Re: Planning Application No. 3/2025/0588

LETTER OF OBJECTION

Address of Development: Land east of Clitheroe Road, Whalley

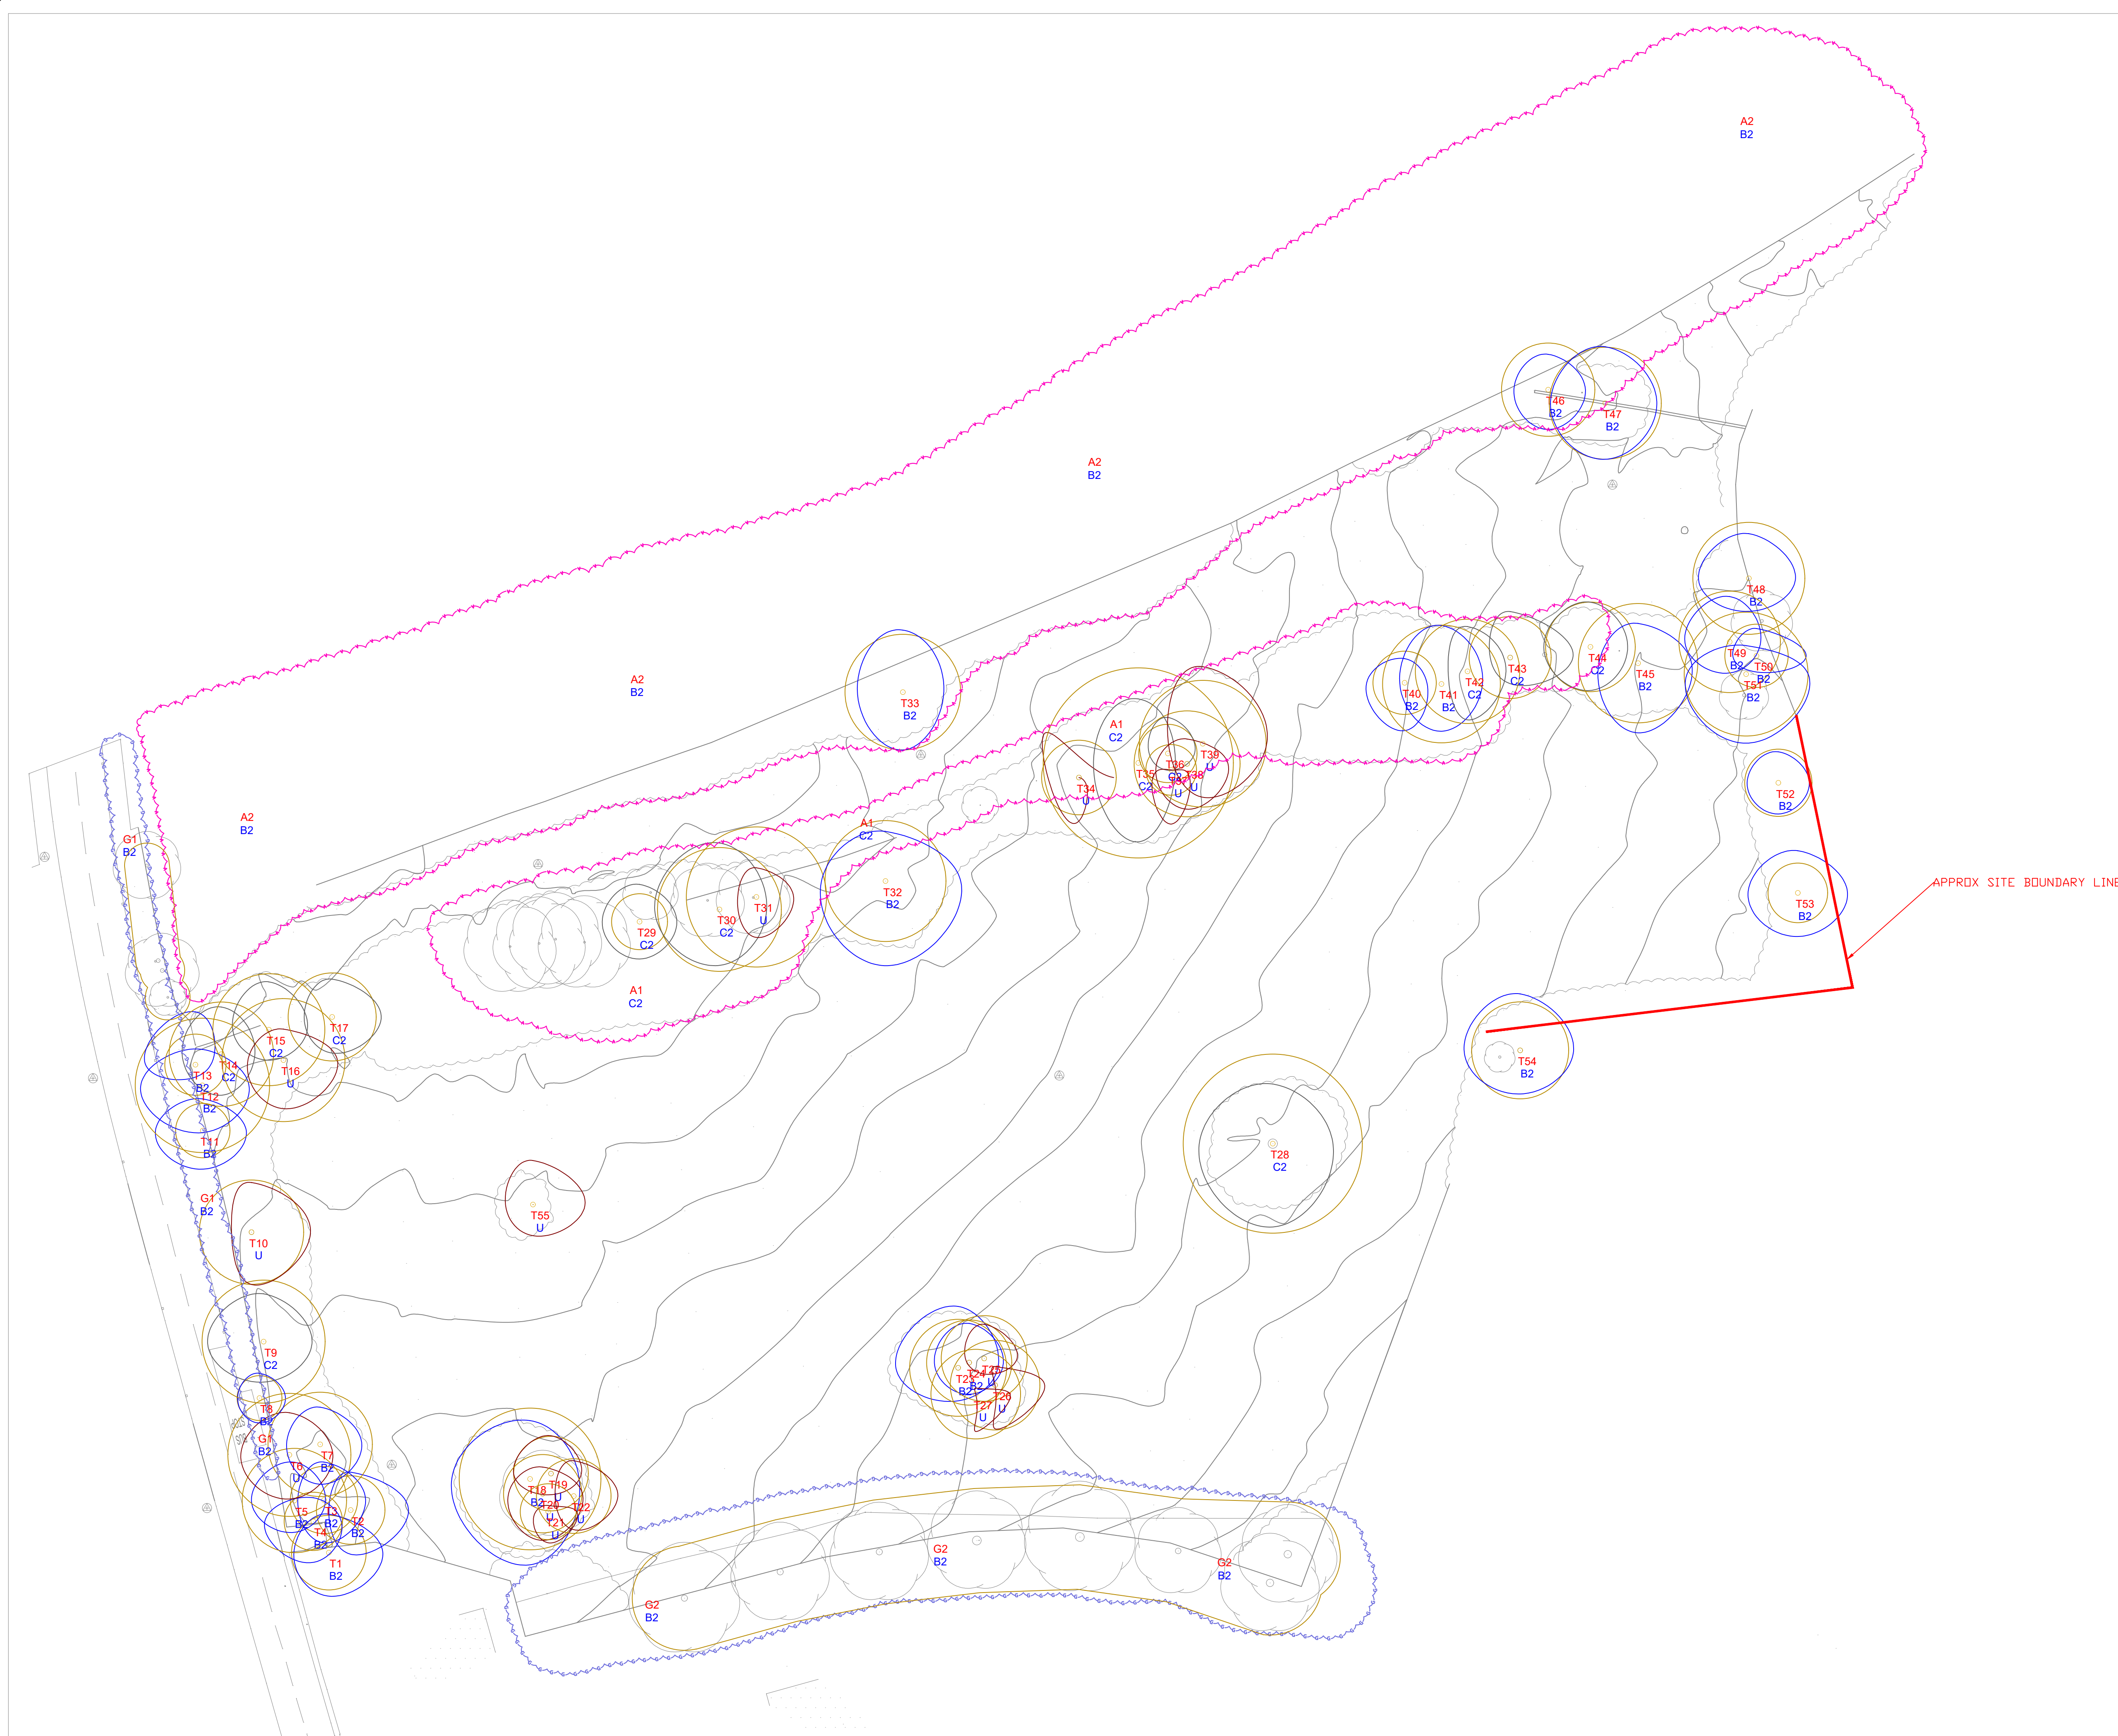
8. As we read it, the application does mention the three mature Lime trees which are on the same side of Bramley Meade Hall's driveway as the proposed development and so are at its boundary, but we submit that the Tree Impact Assessment and Survey refers to these trees inaccurately or misleadingly. The arboricultural consultant says that "no trees along its boundaries" have TPOs. This is wrong. These trees are all marked as G2 on the plan. In the Report they are referred to as being off site by "the highway". But there is no highway.

They are in the verge of the private driveway to Bramley Meade Hall. All have TPOs. Their height is estimated at 25 metres. We note the root protection provision but this is to protect the trees during construction. We are more concerned by safety risks after construction. The report does not however appear to indicate how many metres from those trees the closest of the houses would be, but we would estimate much less than 25 metres. Some of the houses of plots 13-22 and 37-46 would appear to be within a few metres of those very tall trees and well within falling distance. Is there not some restriction on building new houses so close to mature trees? Would it not be good practice only to build at least as far away as their height, in this case 25 metres?

9. Indeed, they would probably be within falling distance of a [REDACTED] which is the same height and maturity as the G2 trees (and also has a TPO). This tree is not mentioned in the report and is not covered by the root protection proposal although it is closer to our house (within damaging distance if it fell)
